**From:** [Brenda Larsen](#)  
**To:** [Jeff Watson](#)  
**Subject:** RE: BL-10-00040 Stuart Vista  
**Date:** Tuesday, November 30, 2010 8:22:42 AM

Re: Stuart Vista (BL-10-00040)

DWN. BY	KMM	DATE	08/18/10	JOB NO.	12854
CHKD. BY	TSL	SCALE	1" = 200'	SHEET	2 OF 3

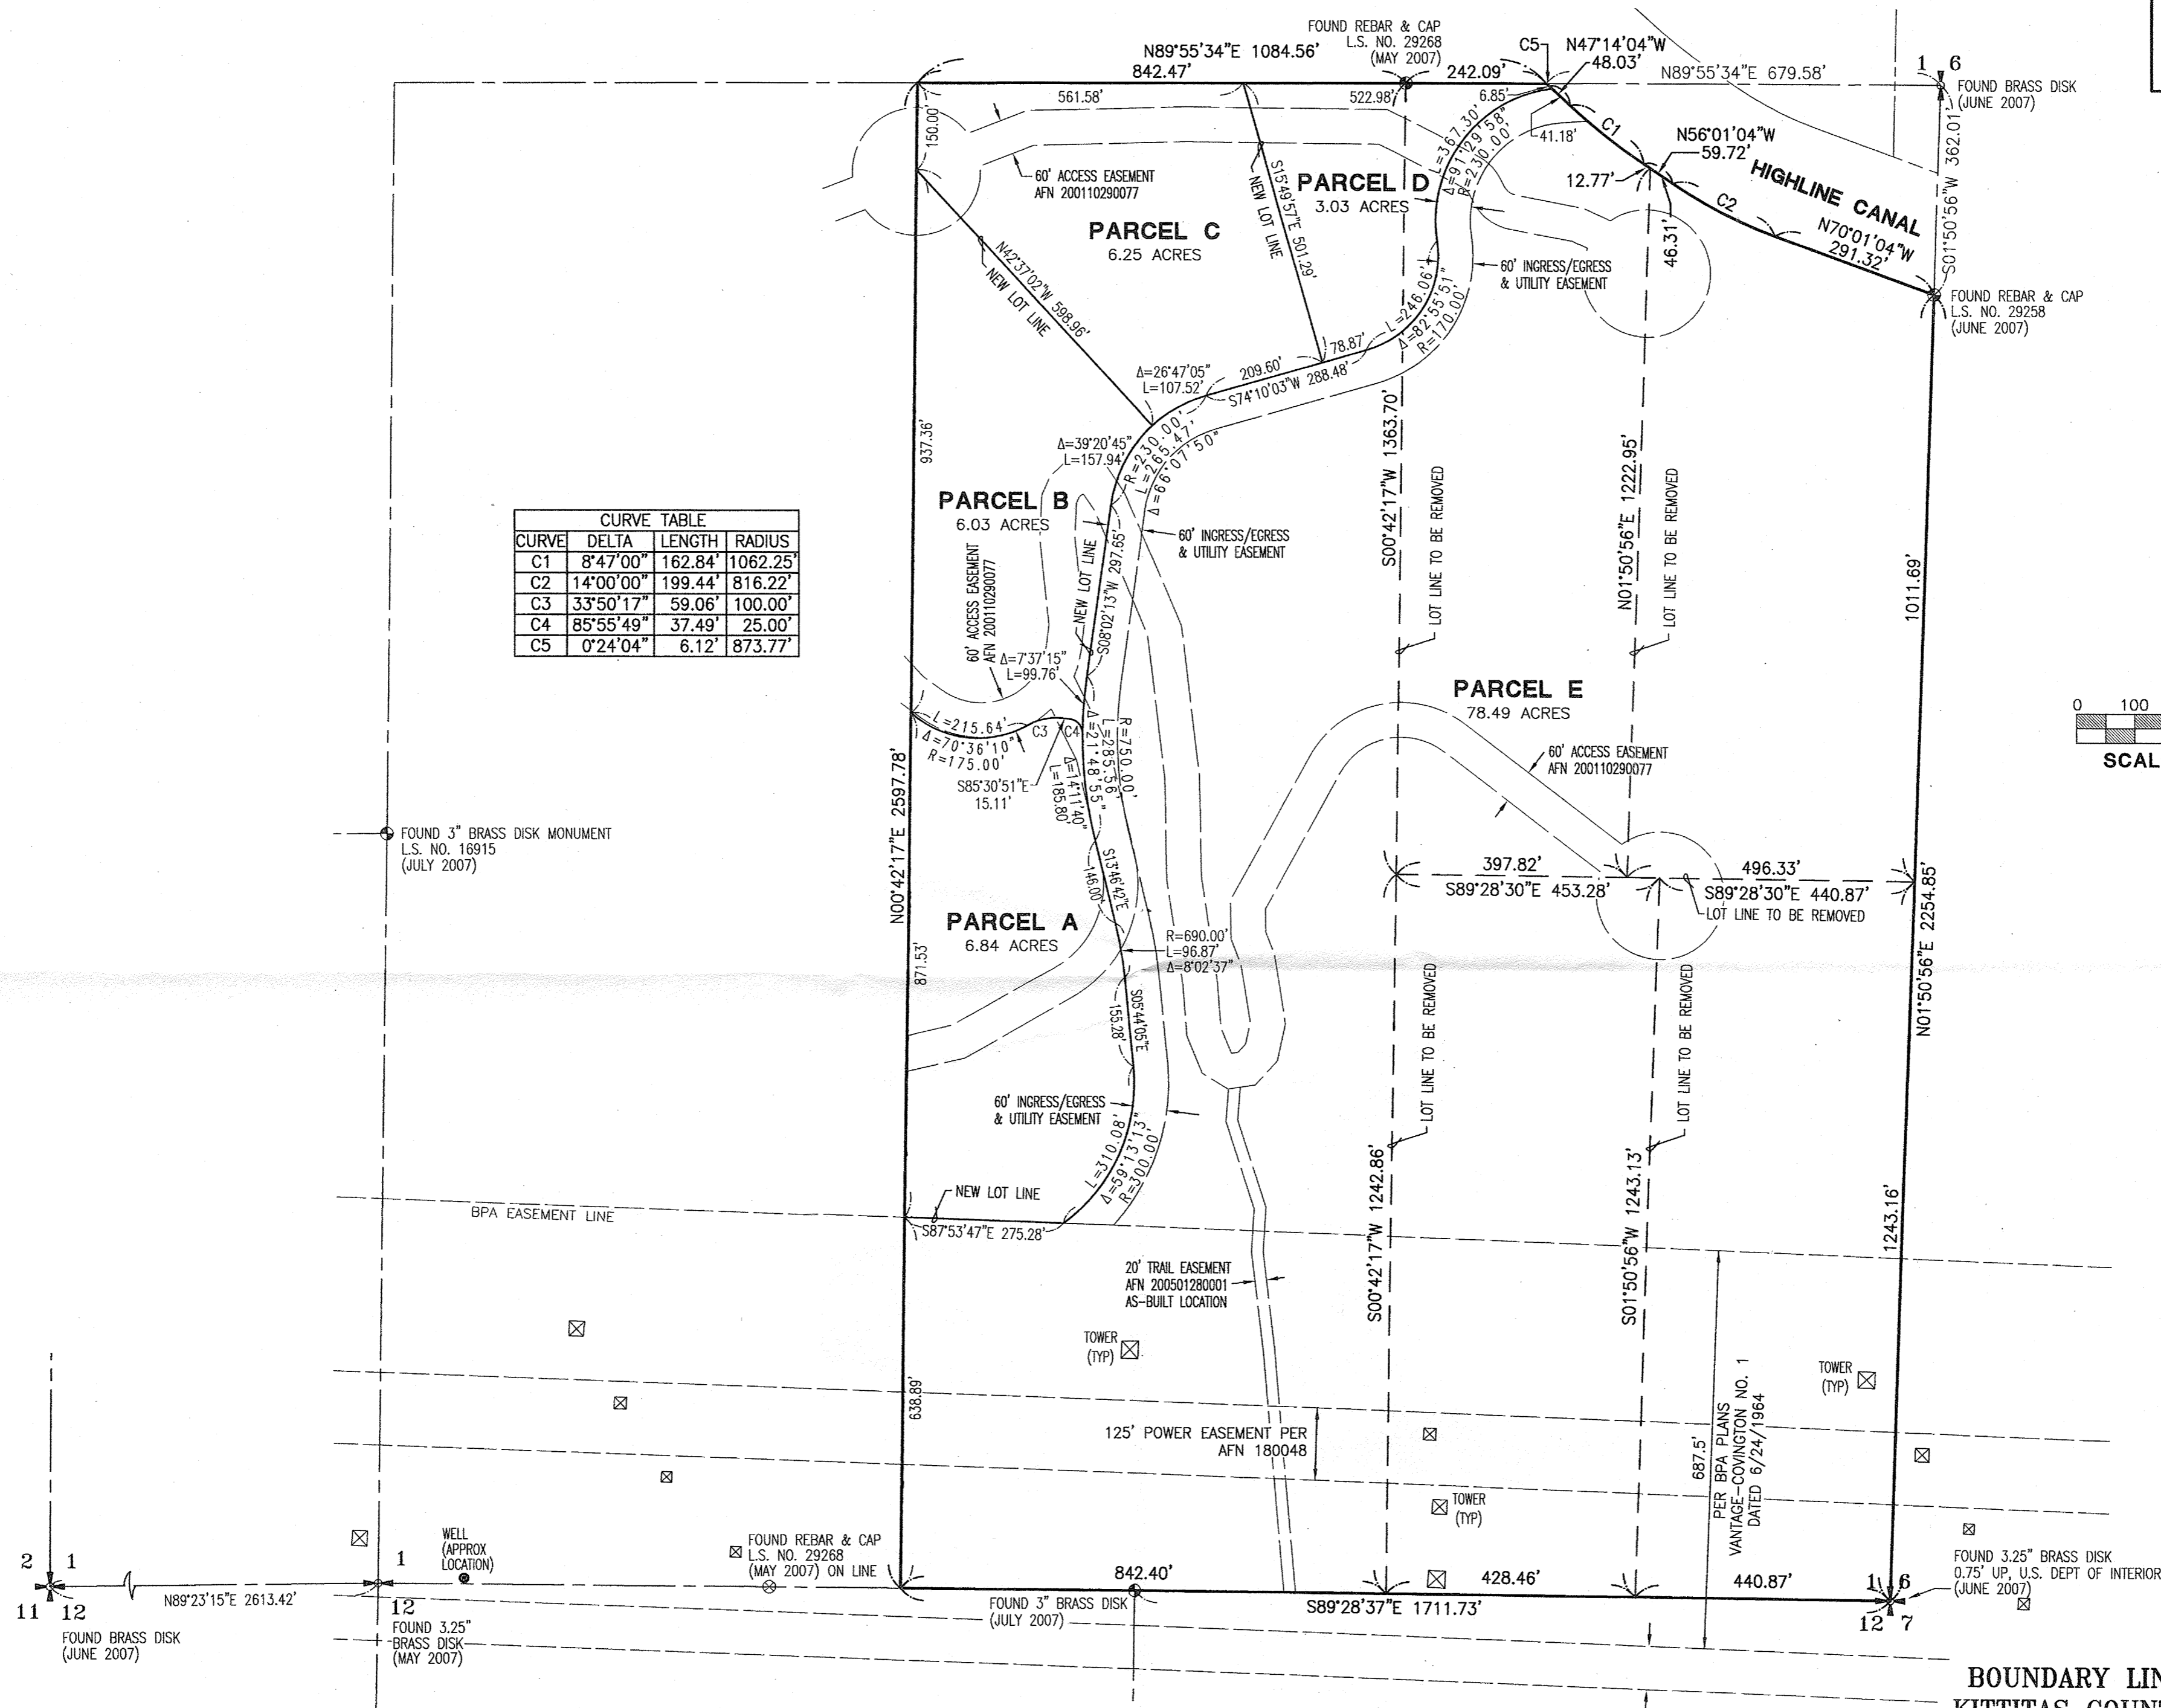
- Ensure that boundary line adjustments do not infringe upon existing structures, to include propane tanks, etc.
- Creation of any additional roads or access must comply with the International Fire Code.
- All future development must comply with the International Fire Code.
